## MMC Parking Garage / Saint John Street Evaluation Memo

Mon, Feb 24, 2020 at 12:49 PM

In response to Mr. Green from MaineHealth, DPW cannot recommend that the proposed signal at St. John Street at D Street be turned on until the signal meets at least one MUTCD Signal Warrant.

Proposed Garage Access Signal Warrant
2022 Postdevelopment DHV

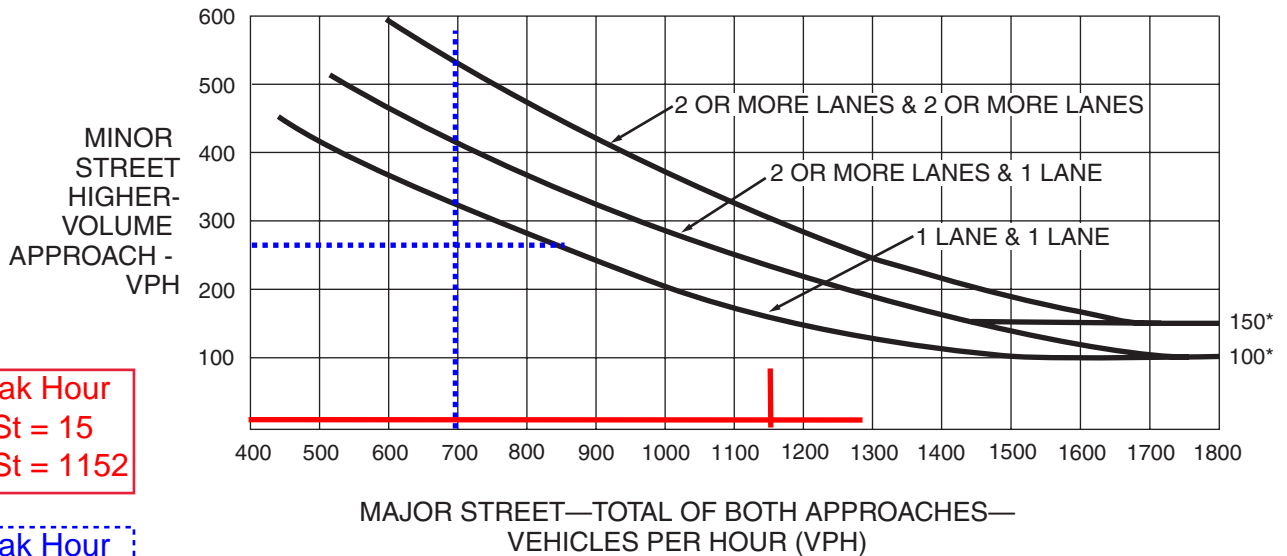
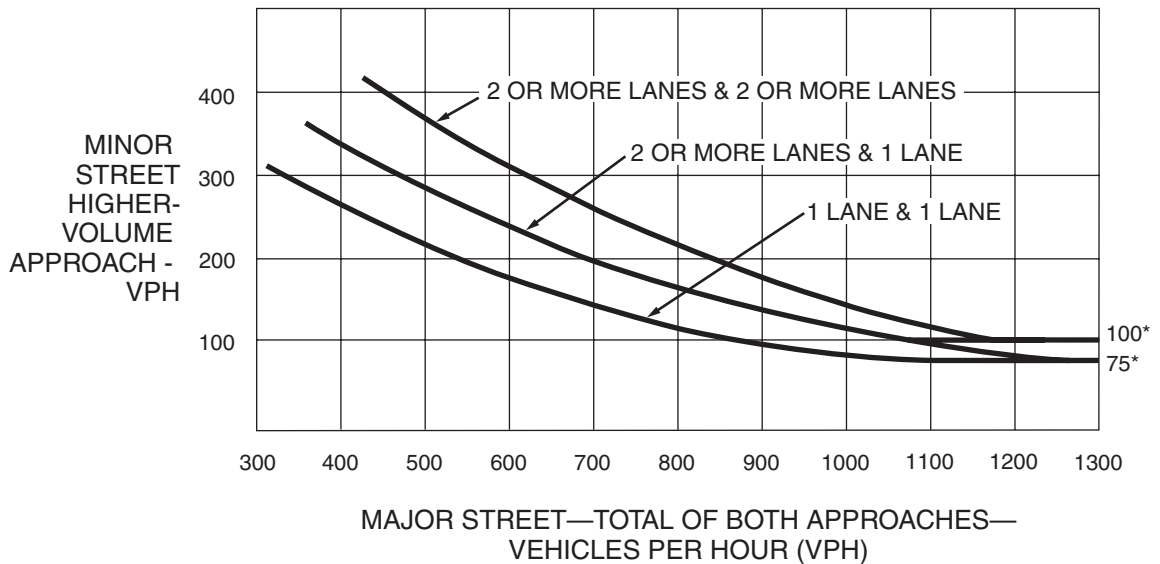
Traffic signals are a matter that concerns MaineDOT. MaineDOT approval is required before a signal can be activated. Based on the limited data provided to the city so far, it is almost certain that MaineDOT will not approve of a new signal at a location that does not yet meet warrants. Their position in the past has been very consistent: signals at locations that do not meet warrants should not be installed, and existing signals at locations that do not meet warrants should be removed. The city is supportive of this position and has worked with MaineDOT to remove unwarranted signals.

In order to determine if a signal meets warrants, typically 12 continuous hours of counts are required. Counts should consist of vehicle, pedestrian, and bicycle counts. Gorrill Palmer provided only peak-period vehicle counts in their memo, though it does appear more hours were counted. Warrant 1 considers the peak 8 hours of traffic throughout a given day; Warrant 2 considers the peak 4 hours of traffic in a given day; Warrant 3 considers the single highest peak hour of traffic in a given day; and Warrant 4 considers pedestrian volumes. The data provided by Gorrill Palmer to date has not suggested this location meets Warrant 3, and given the heavy peak periods associated with the parking garage, it is unlikely that Warrants 1 and 2, which have higher thresholds for meeting the warrant, will be met either. Gorrill Palmer did not provide pedestrian counts, so Warrant 4 could not be analyzed, but it is unlikely that a signal will be warranted based on Warrant 4 unless pedestrian volumes are robust. Note that meeting a warrant does not necessitate a signal, it only suggests that one should be considered; meeting multiple warrants strengthens the case for a signal.

The applicant should work with MaineDOT directly. Their traffic consultant, Gorrill Palmer, will be able to facilitate this communication. It is Gorrill Palmer and MaineHealth's responsibility to make the case that a signal is warranted; the City will defer to MaineDOT's decision.
